Response to Comments

Project Name: English Crossing Townhomes

Project File Number: PA23-012

Review Completion: September 14, 2023

SHEET
 P1 of P3
 24x36
 PA 23-12

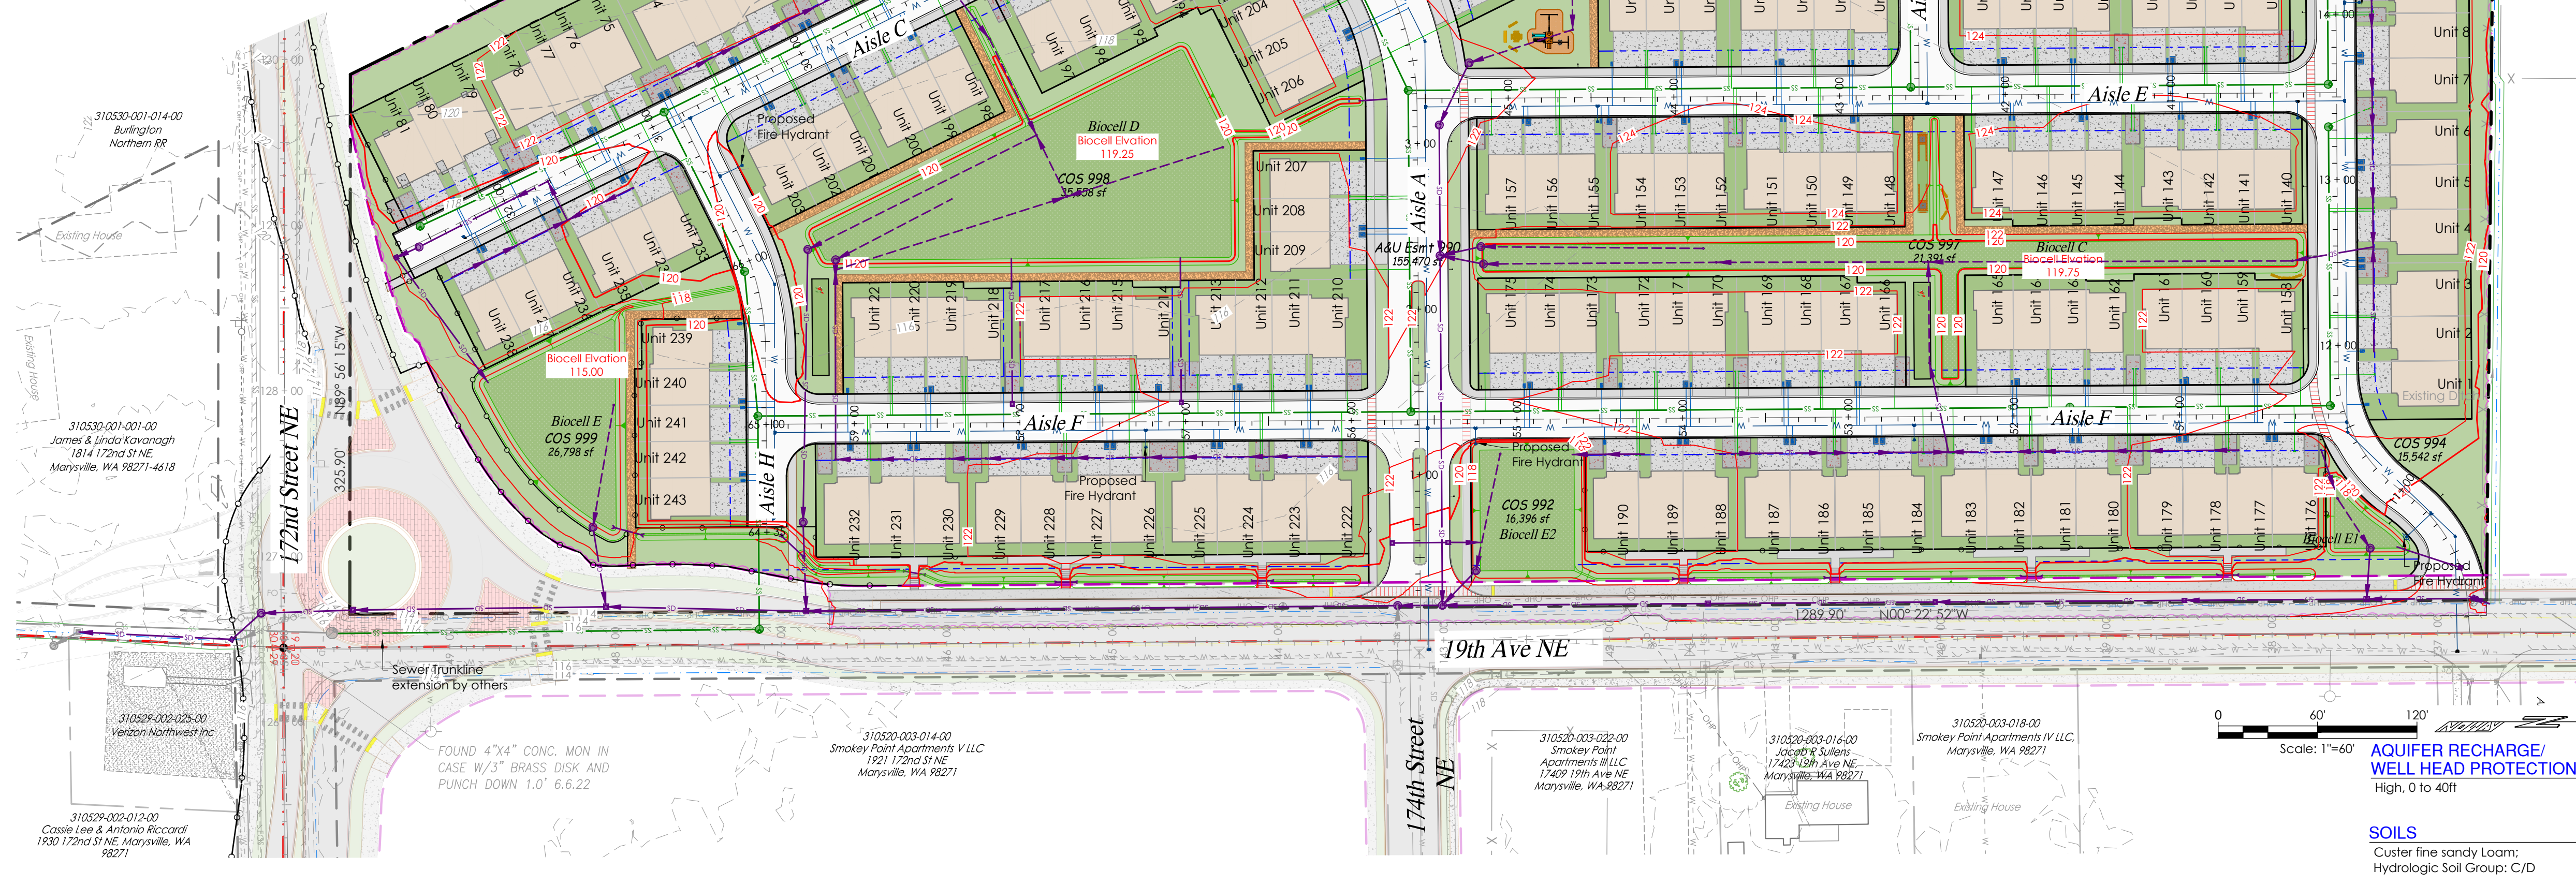
CITY COMMENTS	LAND TECH RESPONSE
<p>5. Pedestrian connections are required from entries of the units adjacent to 19th Avenue (Units 175-190, and 222-232). Installation of stairs will likely be needed to address the grade change. These connections shall be depicted on the site plan. This is a code requirement and is expected to be a condition of approval.</p>	<p>Issue due to some bad examples of the alternative. We are proposing a stair and sidewalk for each building.</p> <p>Due to slopes on 19th, a bioswale is the only feasible way to convey stormwater along 19th. Having 26 sidewalks crossing that bioswale would compromise its effectiveness.</p>
<p>6. Consistent with MMC 22C.065.130, Street Connectivity, new development in the mixed use zones shall provide an integrated and connected network of streets to provide "direct" walking route options, orientation, a sense of place, and multiple travel route options. Blocks shall be designed to provide vehicular connections at intervals no greater than 600 feet and pedestrian access at intervals no greater than 300 feet (200 feet is preferred). <u>Please add one additional access from Aisle H, between Units 88 and 89 as shown below, to meet this requirement.</u></p>  <p>The diagram is a site plan showing a grid of units and streets. Units 88, 89, and 90 are on the left side, while units 10, 11, and 12 are on the right. Units 120, 122, 222, and 232 are also shown. A 'Proposed Fire Hydrant' is marked with a green circle. 'Biocell B' is a green area with a 'Biocell Elevation 120.50' label. 'Aisle D' is a street at the bottom. A red dashed line indicates a proposed path between units 88 and 89.</p>	<p>Pedestrian Access from Aisle H to sidewalk on 19th has been added</p>

<p>7. Consistent with MMC 22C.065.130, Street Connectivity, internal paths are encouraged to provide access at intervals no greater than 300 feet to improve pedestrian mobility. These pathways shall be constructed to sidewalk standards for local access roads or be designed as multi-use trail per City standards. Pedestrian access ways shall conform to applicable ADA requirements. <u>The EDDS standards referenced in the response letter are not acceptable. As required by the code section above, the internal paths shall be constructed to sidewalk standards for local access roads.</u></p>	<p>There are two kinds of pedestrian facilities on this site. One is for "street connectivity" required paths per the quoted code. There are also the internal paths or "Neighborhood pathways" per EDDS 3-519 designed more for internal resident movements to neighbors or to recreational facilities or to be used just for recreational walking.</p> <p>These do not meet the use requirements of the Multi-use Trail—they are meant for walking and not for bikes.</p> <p>We have added pavement to the surface of these Neighborhood Pathways.</p>
